**KIRKLEES METROPOLITAN COUNCIL
INVESTMENT & REGENERATION SERVICE**

DELEGATED DECISION TO DETERMINE PLANNING APPLICATIONS

Reference No:	2025/62/91371/W
Site Address:	17, Town Gate, Upperthong, Holmfirth, HD9 3UX
Description:	Alterations to convert one dwelling to two dwellings (within a Conservation Area)
Recommending Officer:	Joanna Rednall

DECISION – Full Conditional Permission

scale 1:500 date 02/2025 sheet size A4 dwg. no. 25/975/05a

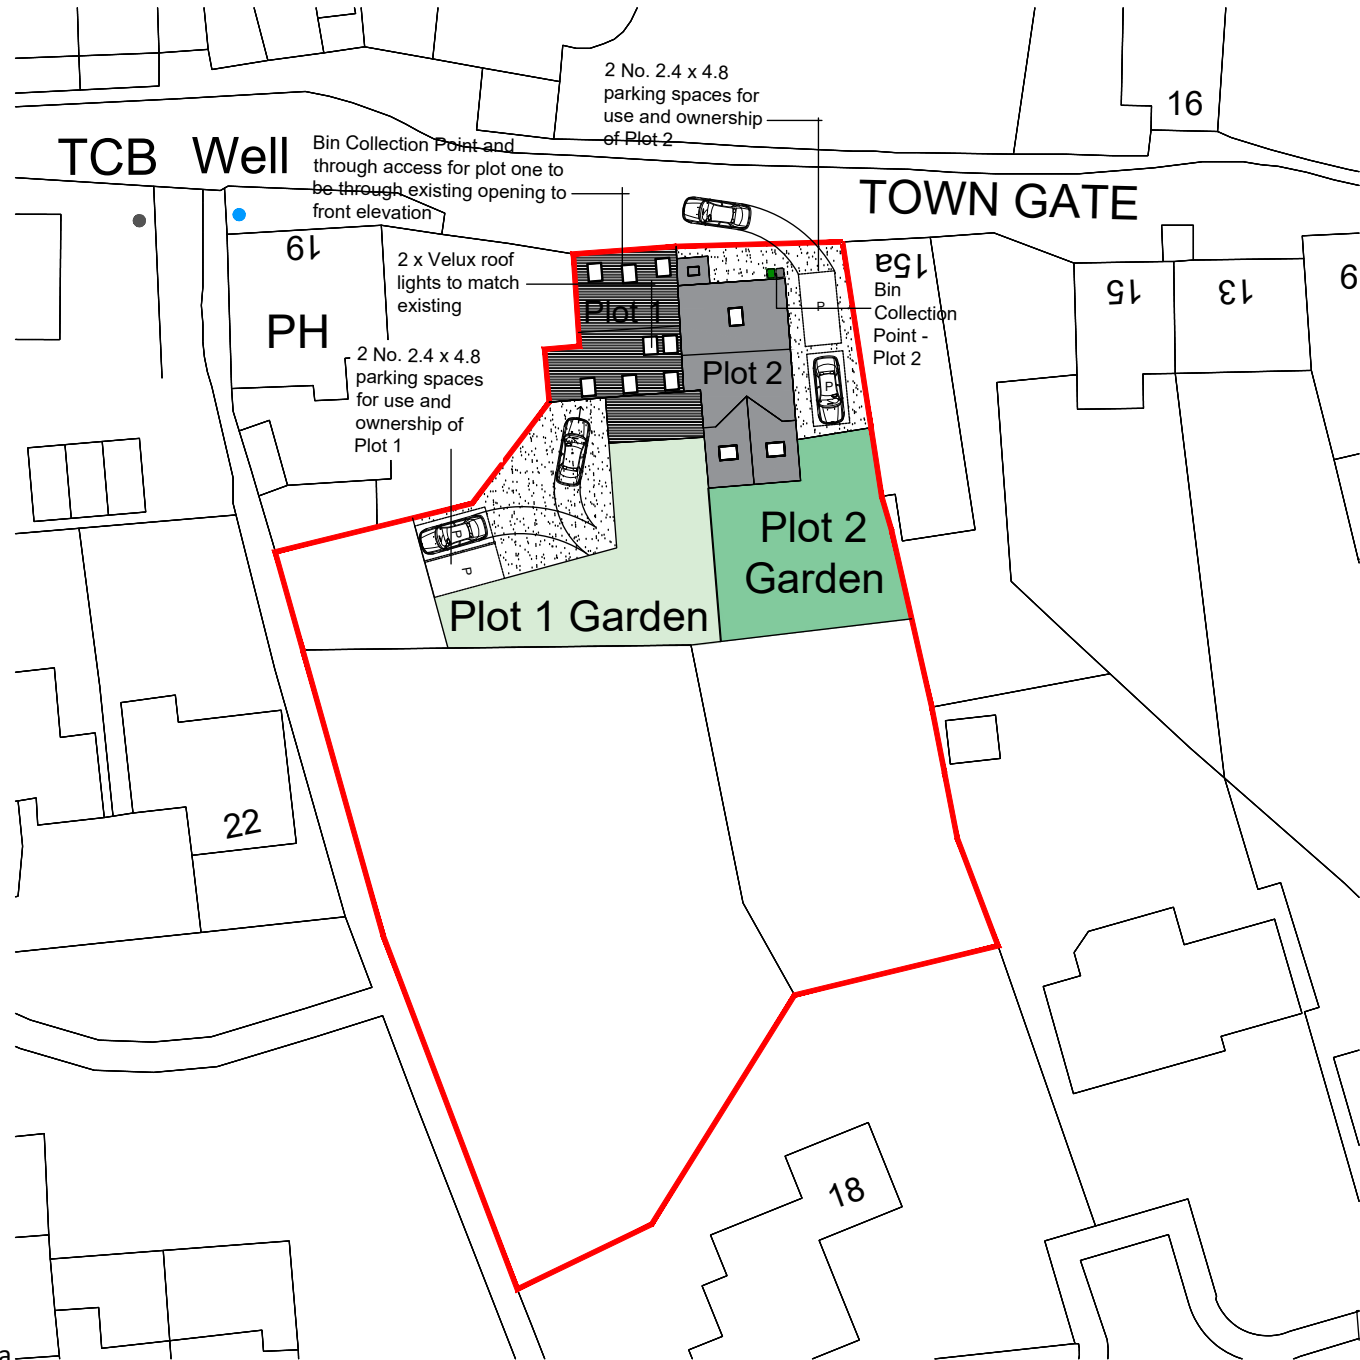
- The parking for Plot 2 is unsuitable
- The swept path diagram for access and exit is misleading as it does not show the pavement opposite or any parked vehicles
- The application will add further congestion on Towngate

For Plot 2, the submitted block plan also includes a swept path diagram demonstrating how the spaces will be accessed. It is acknowledged that on-street parking may occur in the vicinity; however, the submitted swept path shown on drawing 25/975/05a demonstrates that vehicles can safely enter and exit the proposed parking spaces under typical site conditions. Highways Development Management raised no objection to the application on the grounds of access or swept path encroachment.

- The parking for Plot 2 is unsuitable
- The swept path diagram for access and exit is misleading as it does not show the pavement opposite or any parked vehicles
- The application will add further congestion on Towngate
Officer response: These comments are noted. Highway safety and parking considerations have been addressed in Section 4 of this report. KC Highways Development Management were consulted as part of the application process, and their response is also set out within Section 4.
- There is a national and local housing shortage, and the proposal would provide two much-needed homes.
Officer response: This is noted.
